## DEVELOPMENT FACILITATION TEAM

### Planning - Case Comments

**Project Number:** PR-2021-005479

**Project Name:** Lots 1-7, 17, 18, block 7, Waggonman-Denison Addition

Sheet 2 of 2
201515

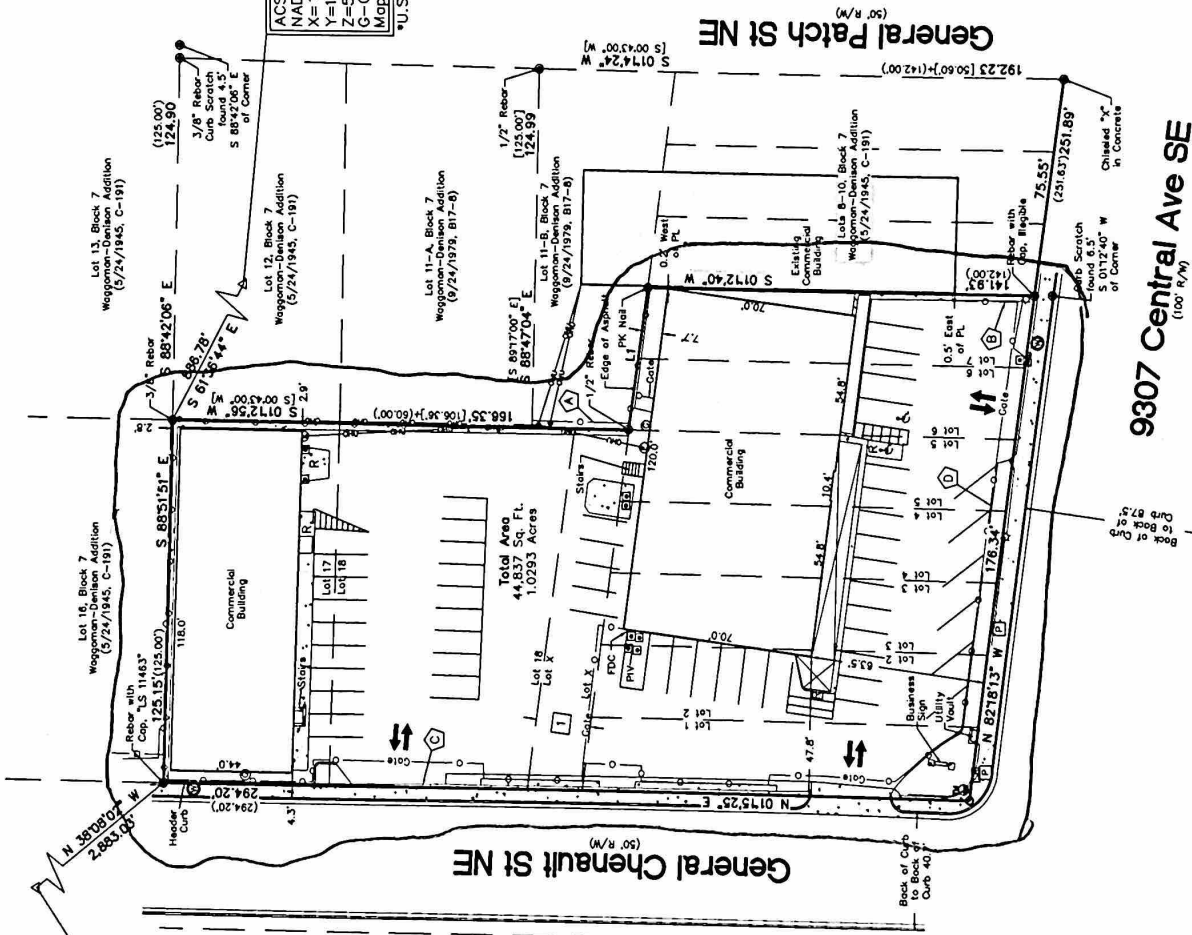
1. Property re-plat as proposed would result in Lot 1-A having the original MX-H zone for the southern portion, and the northern portion added would be MX-M (from former Lot X). This would create a “floating” zone line, and will require obtaining a Zoning Map Amendment prior to re-plat, as per IDO 6-6(K)(2)(c), in Subdivision of Land - Minor:

2. Need to clarify which business requires the parking spaces located on the North side of proposed Lot 1-A, in the area of former Lot X. Will need to provide parking calculations and locations for each business to clarify.
3. If the spaces on the North side of Lot 1-A are part of the required parking for Lot 17-A, a Shared Parking Agreement will need to be recorded related to the use of those spaces prior to re-plat.
4. Need to have cross-lot access easements shown on re-plat or as part of a recorded agreement to allow for access to the parking spaces in former Lot X, on the North side of proposed Lot 1-A.
5. No further comments at this time.
